Please ask for: Nicola Moore
Email: nicola.moore@arun.gov.uk
Telephone: Ext 37944
Our Ref: Y/42/22/PDH
Your Ref:
Date: 29th March 2022

Prior Notification for a Permitted Development (Householder)

Development: Notification under extended permitted development rights for a single storey rear conservatory measuring 3.8m from beyond the rear wall of the original dwelling house, with maximum height off 3.61m and eaves height off 2.25m.
Location: 8 Lambs Cottages Bilsham Road Yapton BN18 0JN

8 Lambs Cottages, Bilsham Road, Yapton, Arundel, BN18 0JN

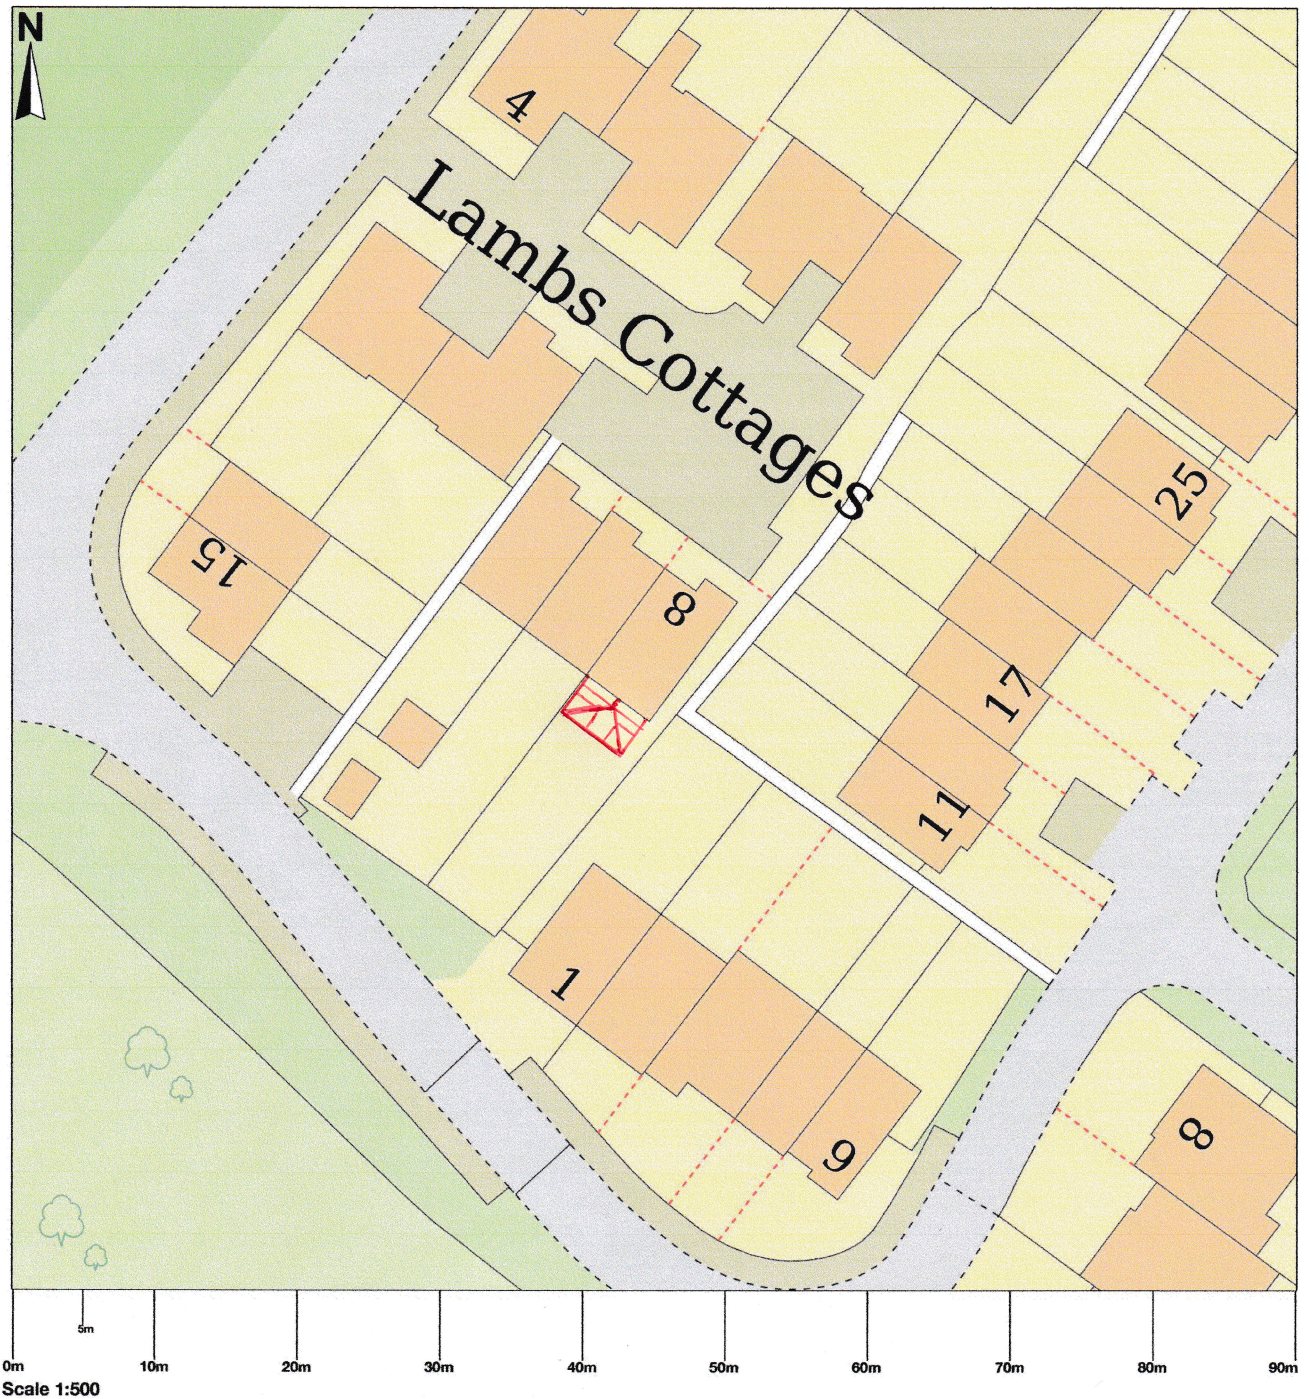
The submitted Block Plan (1:200) does not include the whole site. Please re submit ensuring the complete site location is shown.
